***Residential Development Stage 1 Phase 1
Royal Rehabilitation Centre, Ryde***

MP10_0189 MOD 3

***Redesign of Main Lobbies, Removal of Entry
Portico & Other Minor Changes.***

Director-General's
Environmental Assessment Report
Section 75W of the
Environmental Planning and Assessment Act 1979

Figure 2: Revised disabled access and changes to ground floor unit 5A. (Source proponent's application)

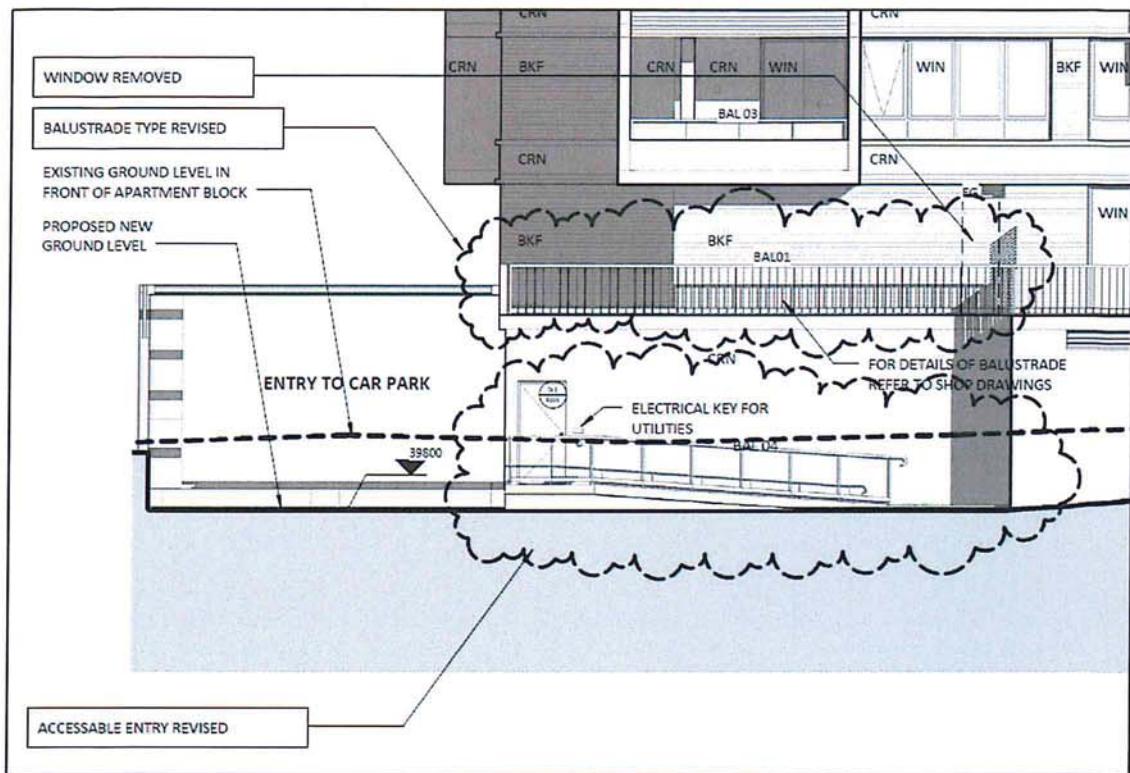
- a reconfiguration of the main entry lobbies to include the apartment's letter boxes;
- provide raked ceilings;
- deleting the entry portico;
- modifications to the disabled entry to the basement to allow for segregated pedestrian and vehicle access to the basement; and
- minor design changes to the roof above unit 28B, a change in the balustrade for unit 5A and the removal of a bathroom window for unit 5A.

The proposed modifications will allow for improved amenity for users of the building. The proposed disabled access increases the accessibility of the basement and allows for persons in a wheelchair to have safe and secure access to the car parking and bin storage area. The access ramp also allows for bicycle users to access the bicycle storage area safely without the need to use the vehicular access ramp or internal vehicle circulation area.

Figure 3: Removal of Entry Portico and revised Lobby B entry. (Source proponent's application)

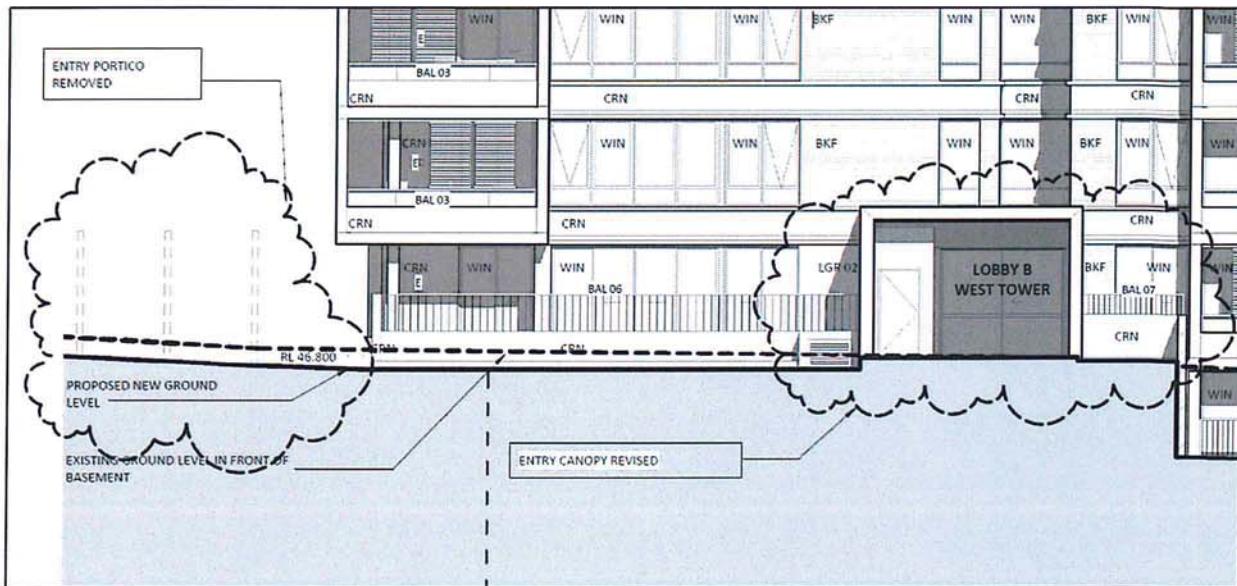
The proposed redesign of the lobbies to include the building's postal boxes allows for a secure and weather proof area allowing residents to access their mail without the need to leave the building. The lobbies are large enough to accommodate the post boxes without impeding access to the building. The raking of the ceiling to increase the flow of smoke presents a improved fire engineering solution to that of the original design.

Figure 5: Removal of architectural features on Level 5. (Source proponent's application)

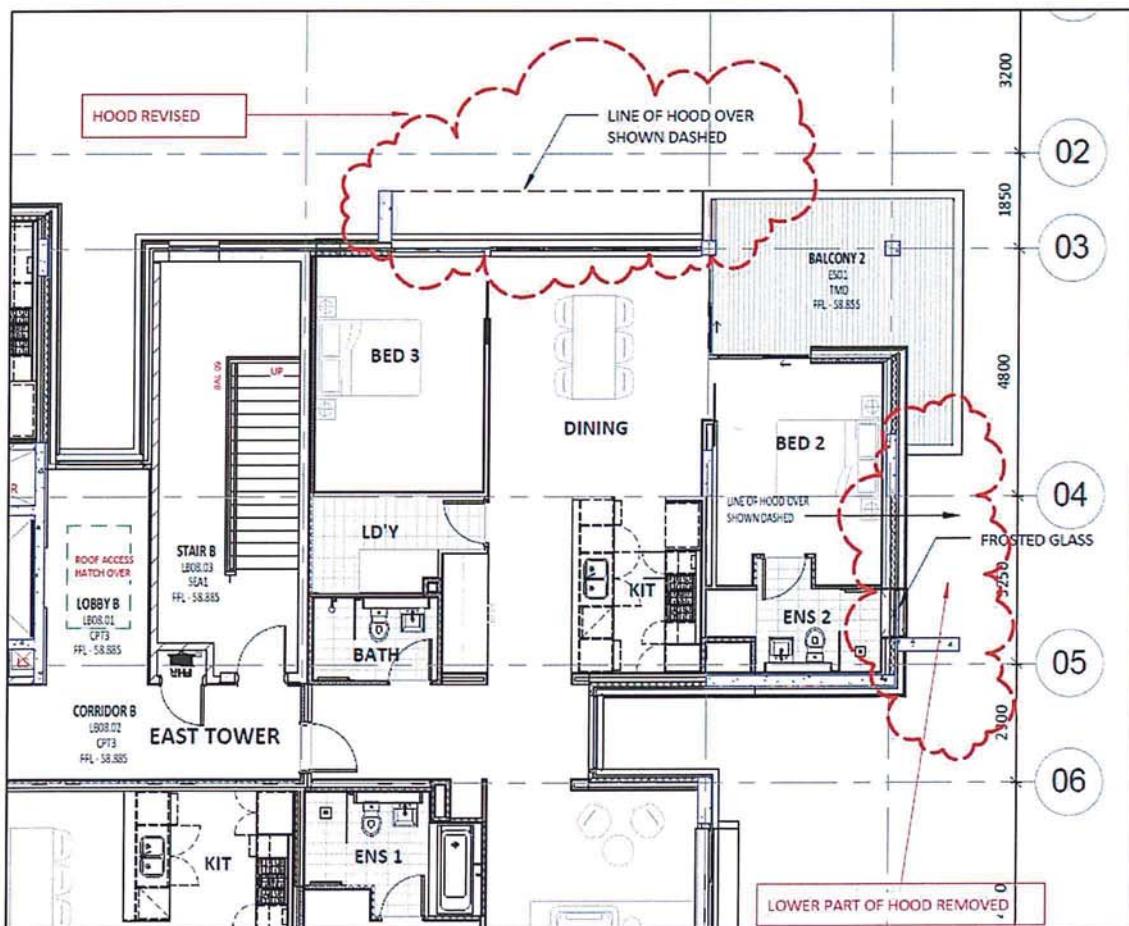
The proposed design changes to the building, including the change of balustrade type on unit 5A, removal of the adjacent planting bed and modification of the roofing sections above unit 28B are minor in nature and are not considered to effect the design quality of the building.
